TfNSW Reference: SYD24/00406/03
Council's Reference: SSD-66826207

**MIXED USE DEVELOPMENT INCLUDING IN-FILL AFFORDABLE HOUSING - FIVE WAYS, CROWS NEST
EXHIBITION OF EIS**

Attachment A: TfNSW comments and recommended conditions

Figure 2 Proposed vehicle site access

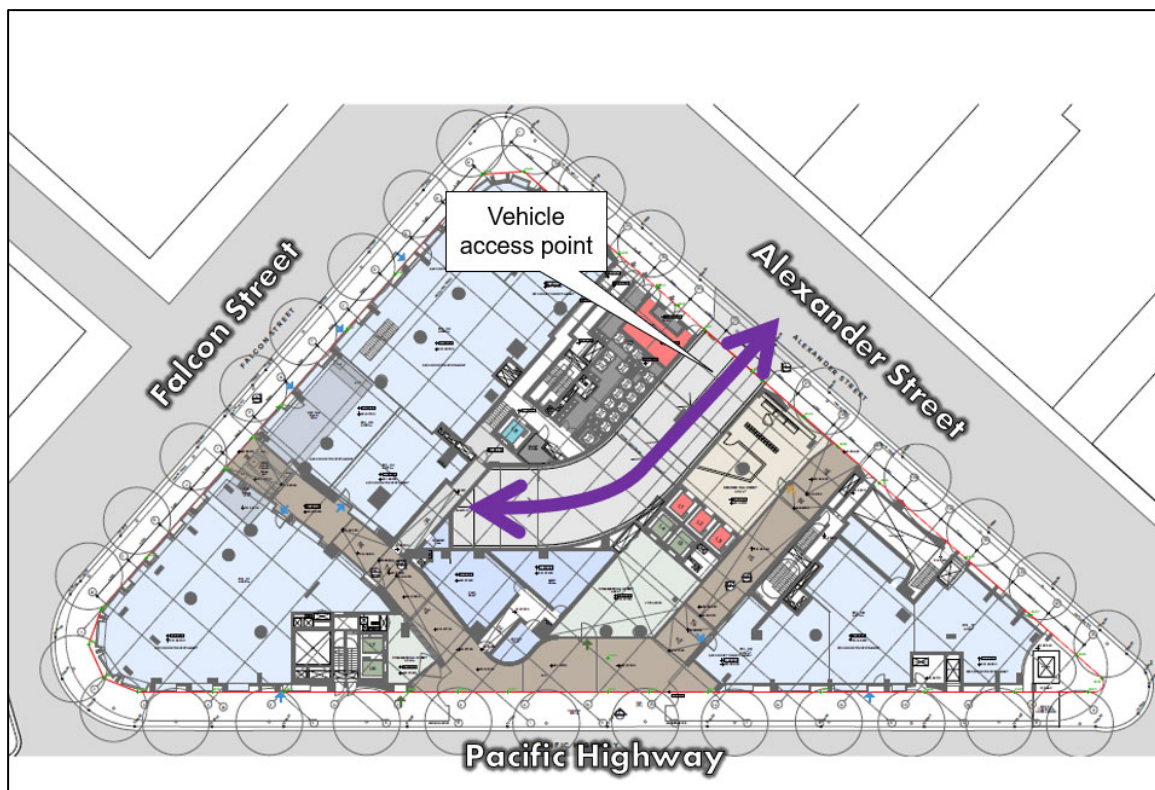
5. Traffic Impact	<u>Comment:</u> a) The proposed vehicular access on Alexander Street should be assessed and designed taking into account the <i>total</i> traffic generation anticipated to be generated by the proposed development. In this regard the following comments are provided which should be addressed in the applicant's Response to Submissions: i. The retail traffic generation rate relied upon was based on a full line supermarket site in an area and at a site not considered to be directly comparable to the subject site in Crows Nest. The proposed development has 8 retail tenancies ranging in size, and it is likely that the site uses could include restaurants / cafés and other retail uses which may result in a higher density of people per sqm when compared to the supermarket surveyed and different mode share. As such, additional justification for the traffic generation rates relied upon are to be provided. ii. There is currently minimal on-site car parking and as such, people driving to visit existing uses within the proposed development boundaries would park on-street or within one of a number of other car parks within Crows Nest. The Transport Impact Assessment prepared by JMT dated 28/3/2/24 uses a discount of the site's existing floor area as justification for the reduced trip generation rates however these existing trips would be spread across Crows Nest and are now proposed to be concentrated in Alexander Street. b) The proposed development site driveway was modelled as an isolated intersection using Sidra Intersection 9.1. Due to the closely spaced intersections and platoons created by those intersections and the queuing that is typically observed northbound on Alexander Street adjacent to the proposed development, additional information is required in relation to the existing northbound queues and how often they are observed to extend past the proposed development driveway during weekday and weekend peak periods. c) Motorists turning right into the proposed site access on Alexander Street have the potential to cause queueing on Alexander Street which could extend back to the signalised intersection of Falcon Street / Alexander Street, impacting signal operations. Consideration may need to be given to the removal of some on-street parking in the kerbside lane on Alexander Street (southbound) in peak periods to allow space for vehicles to pass vehicles turning right into the site. North Sydney Council should be consulted in this regard.
